June 21, 2024

Re: 7-Brews Coffee
4331 Wyoming Blvd. NE
30-Day Temporary Certificate of Occupancy
Transportation Development Final Inspection
Architect's Stamp dated 04-19-23 (G19-D004F)
Certification dated 06-17-24

TCL-2

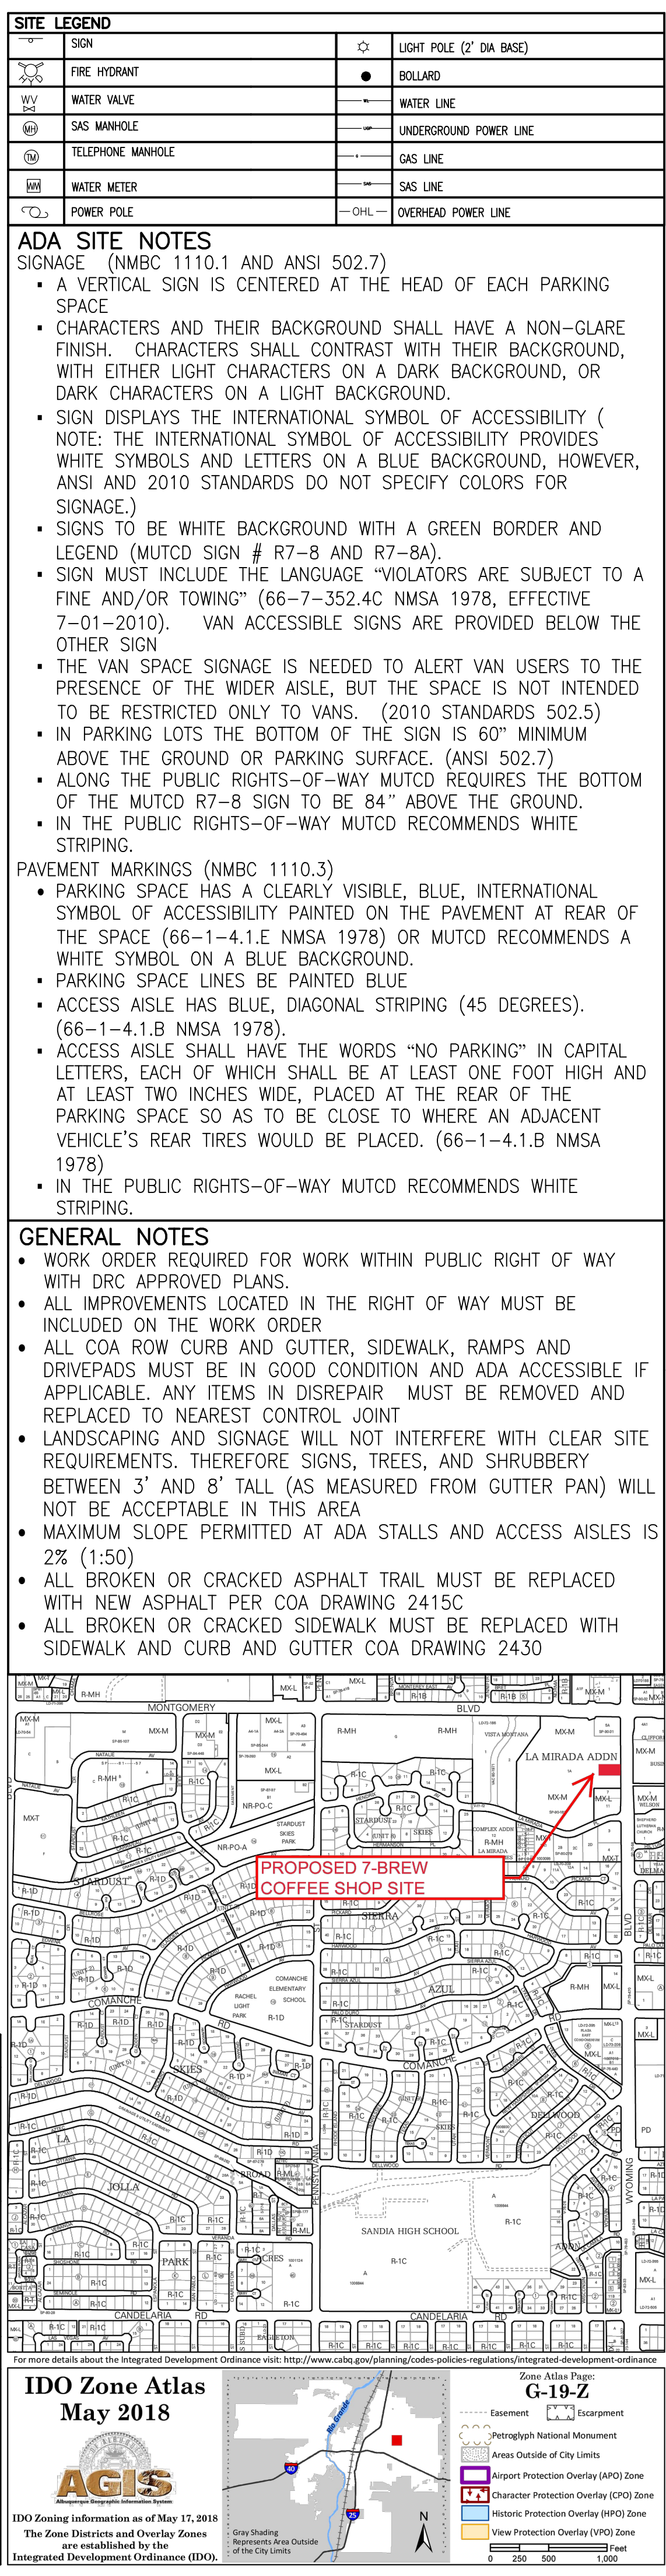
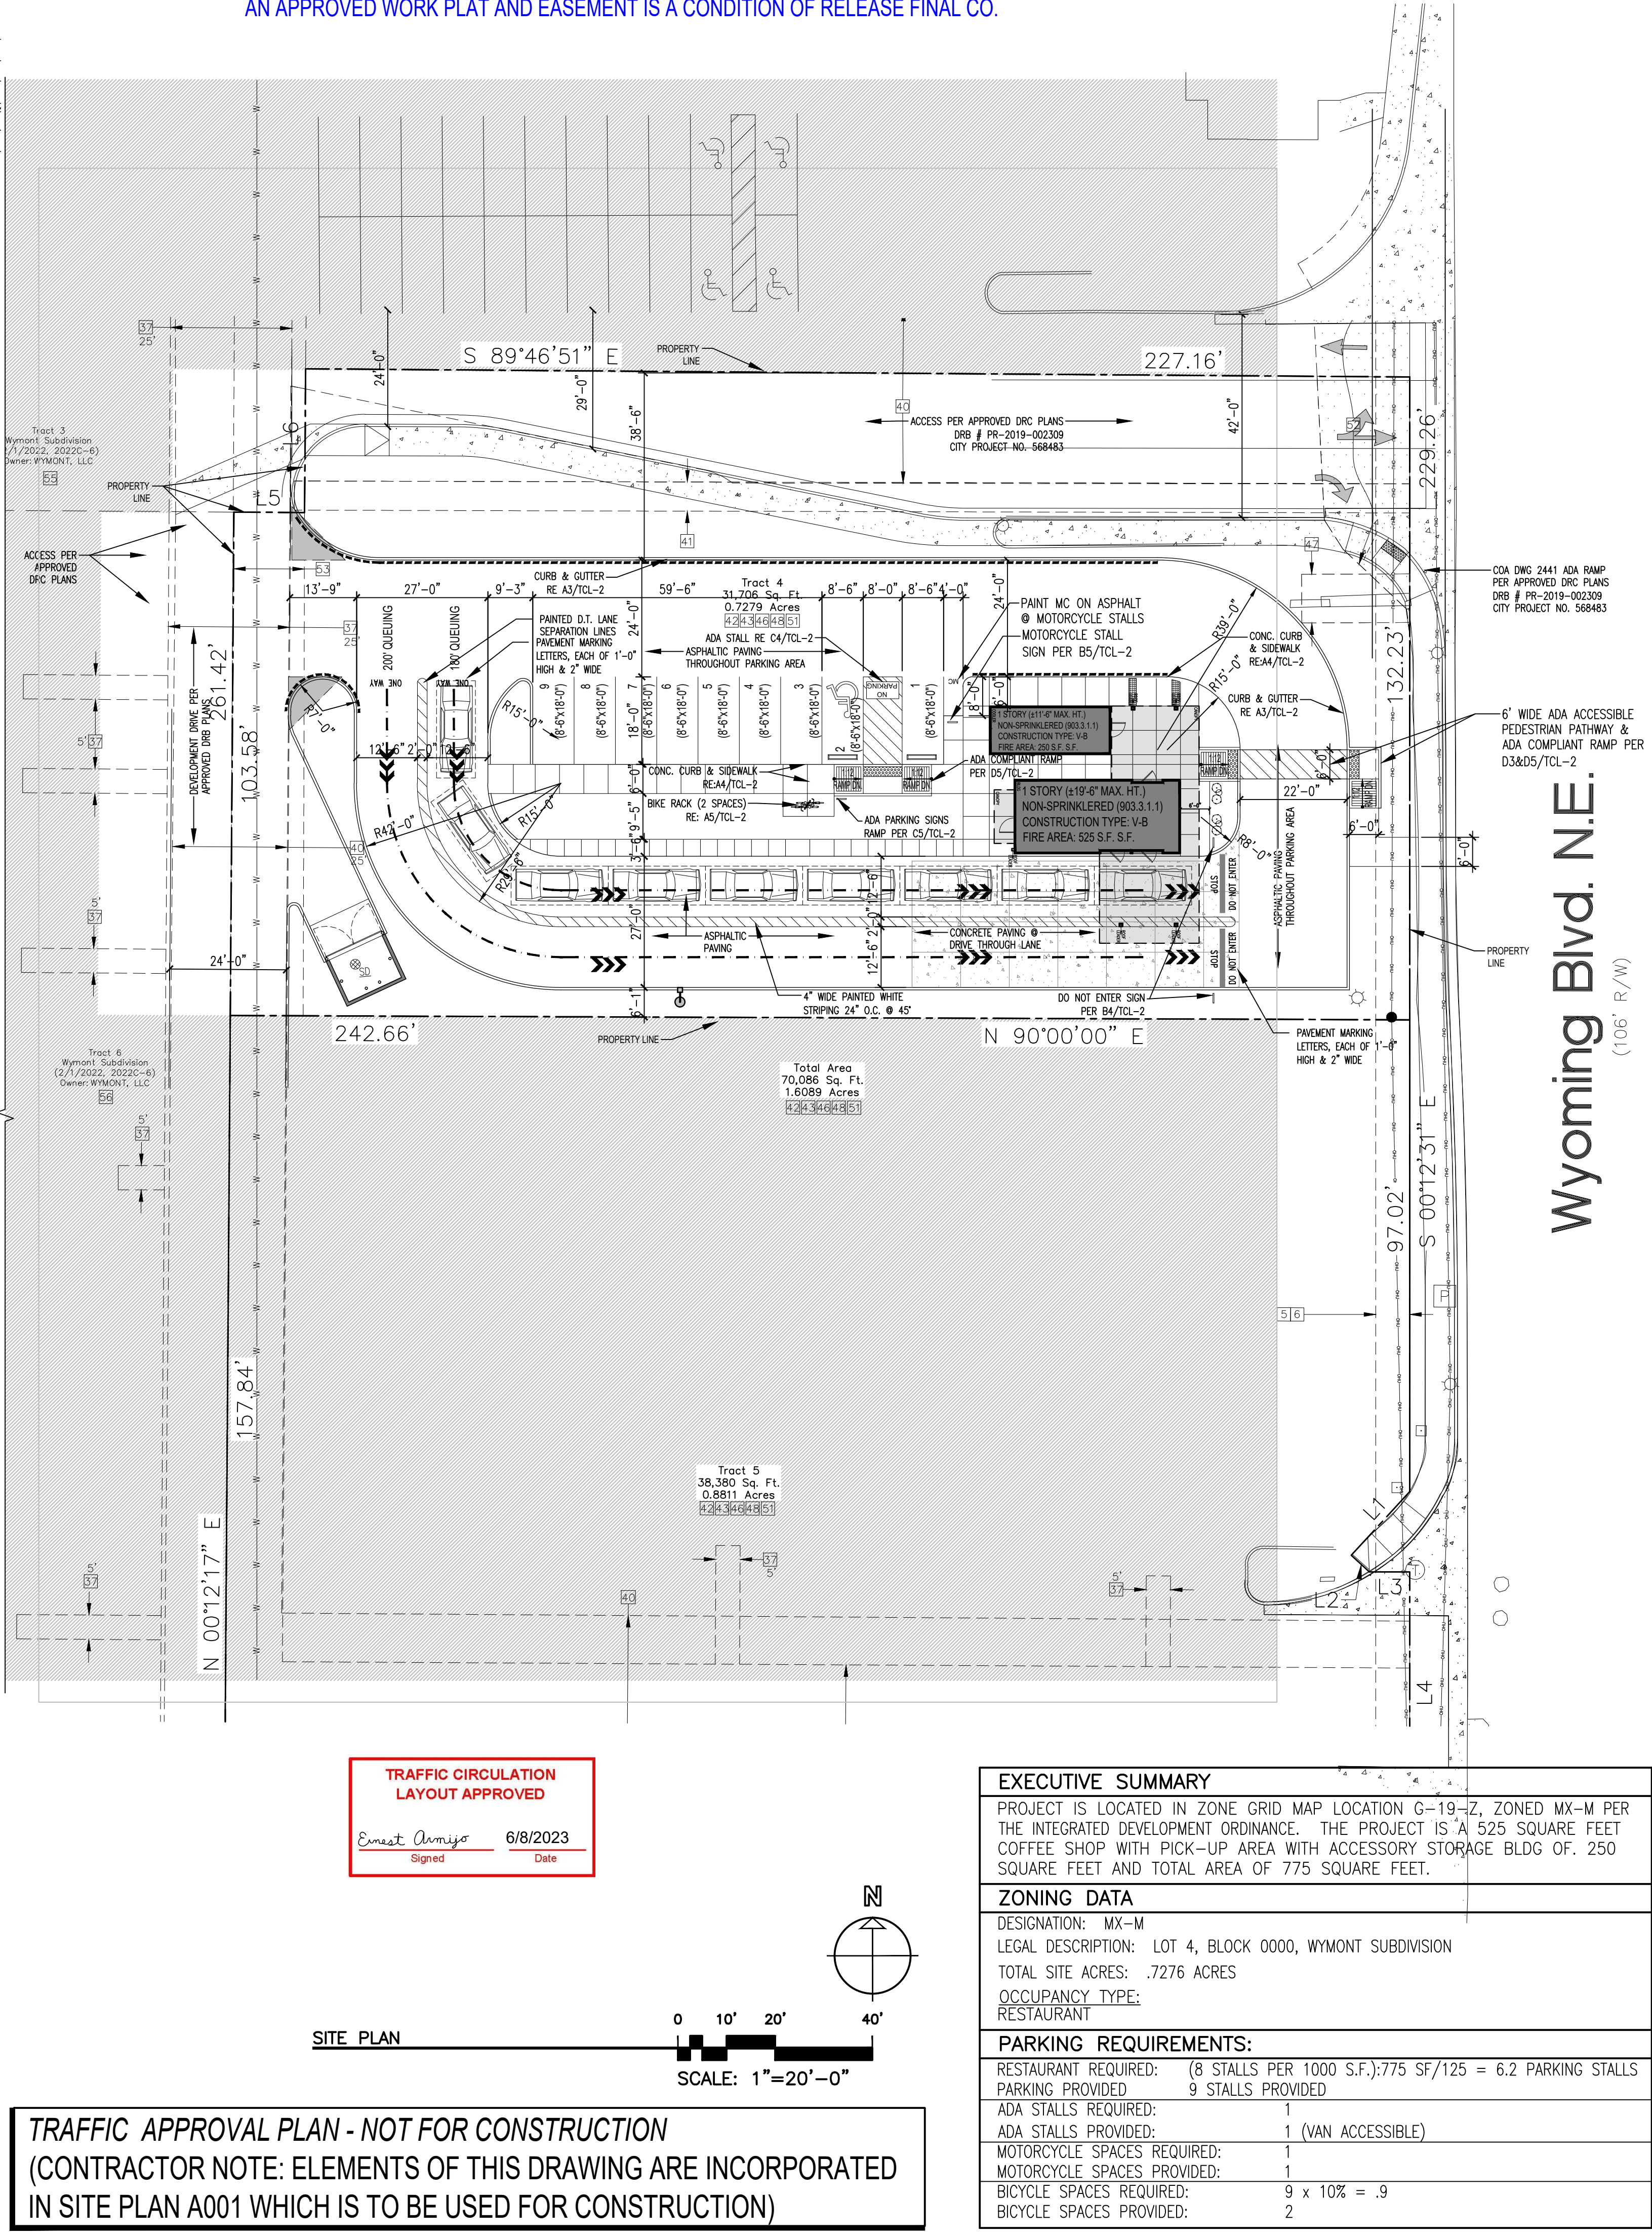
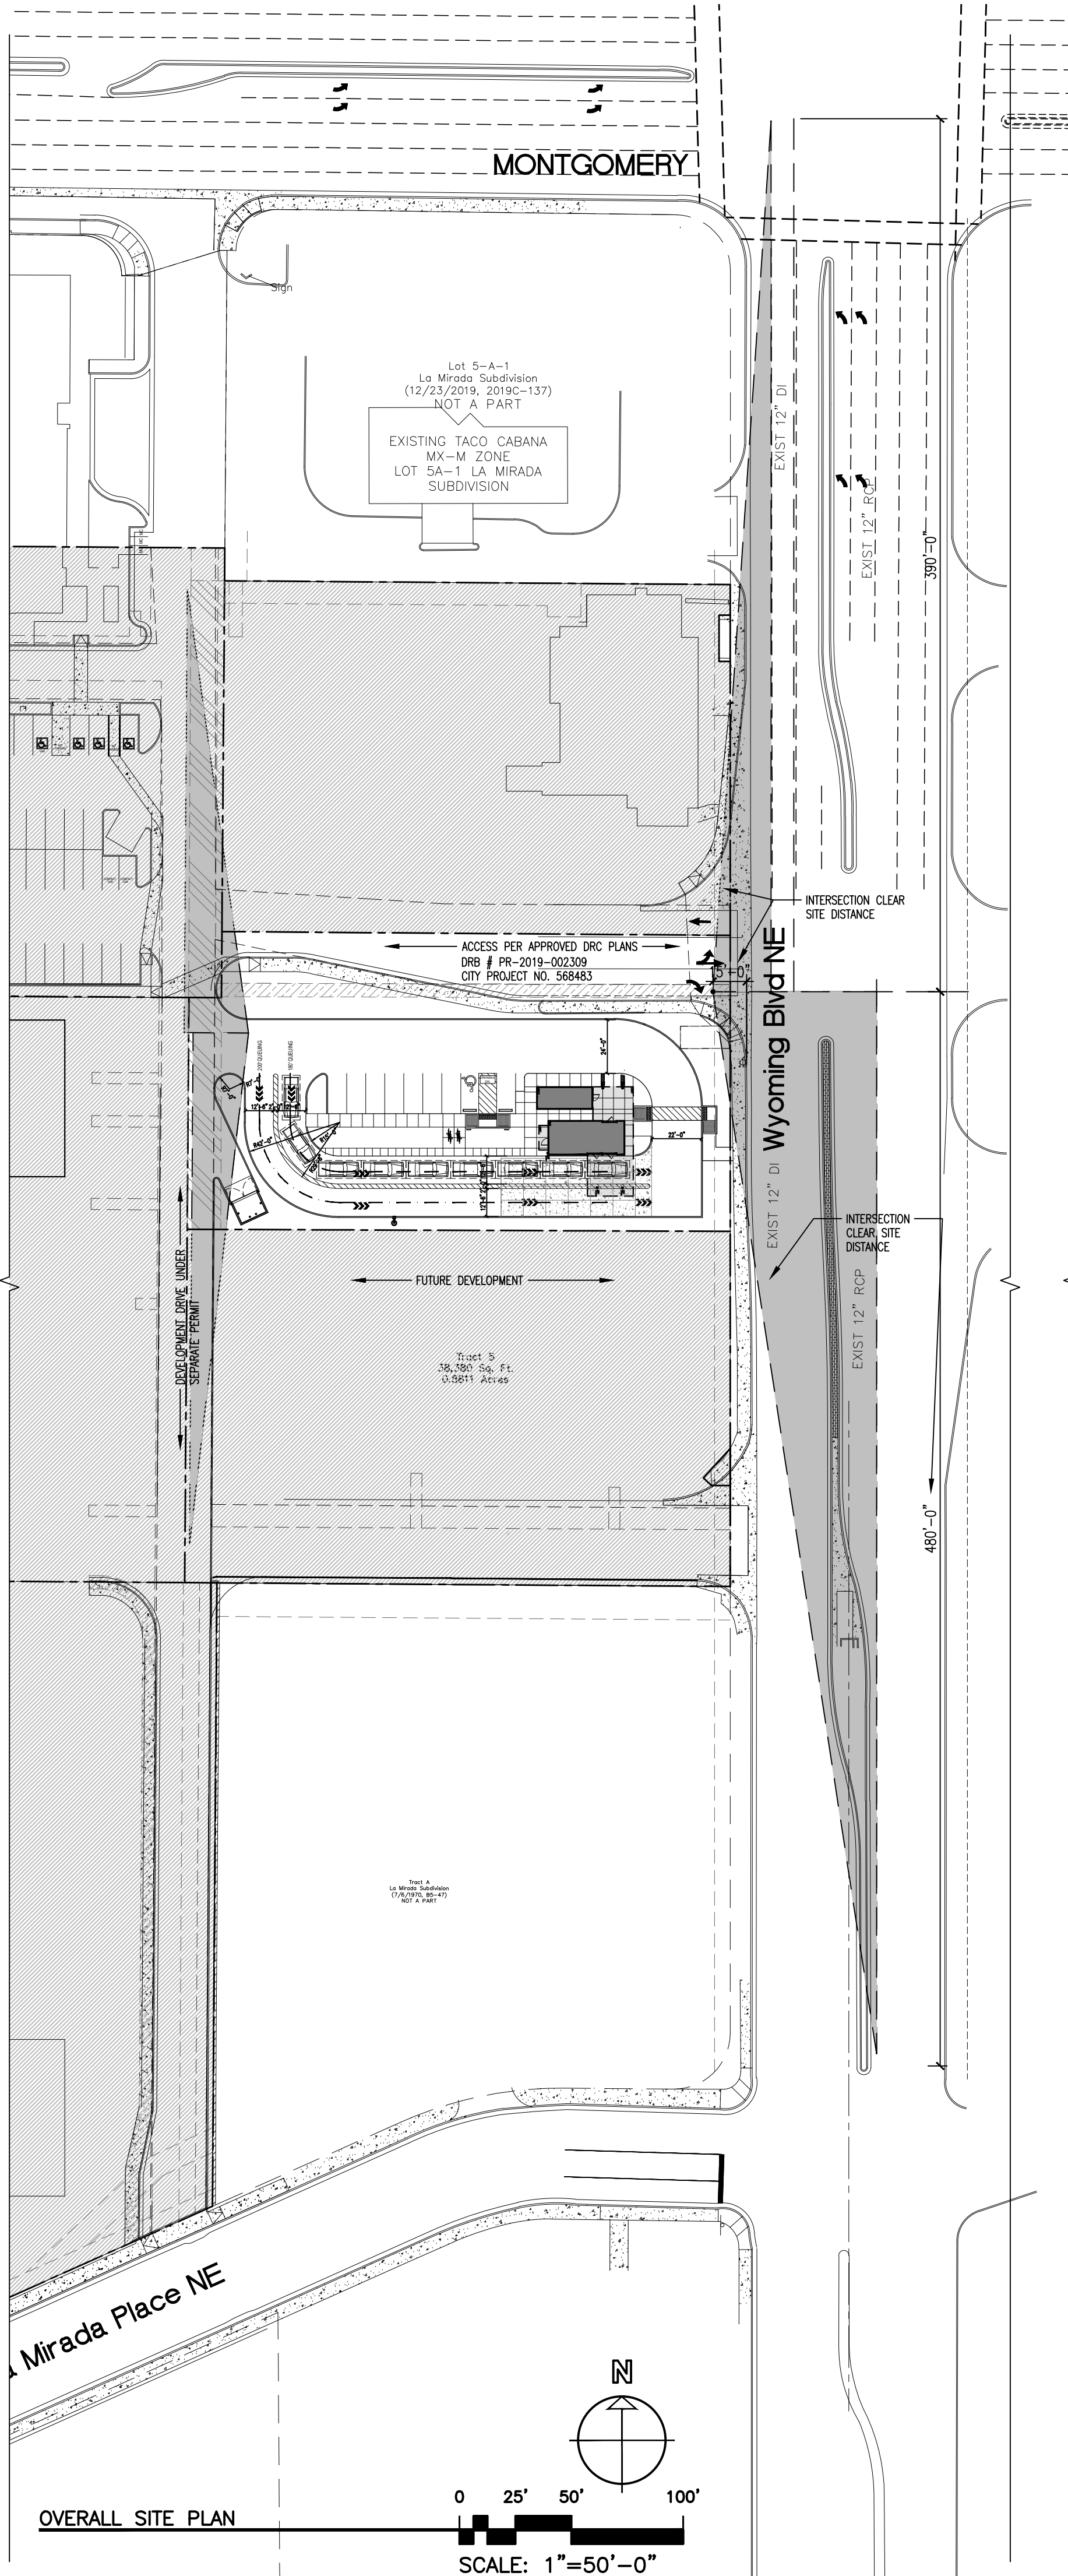
- The minimum ADA parking space width should be 8.5 ft. However, per site visit it was only 8 ft. wide. Please provide an 8.5 ft. wide ADA parking space.
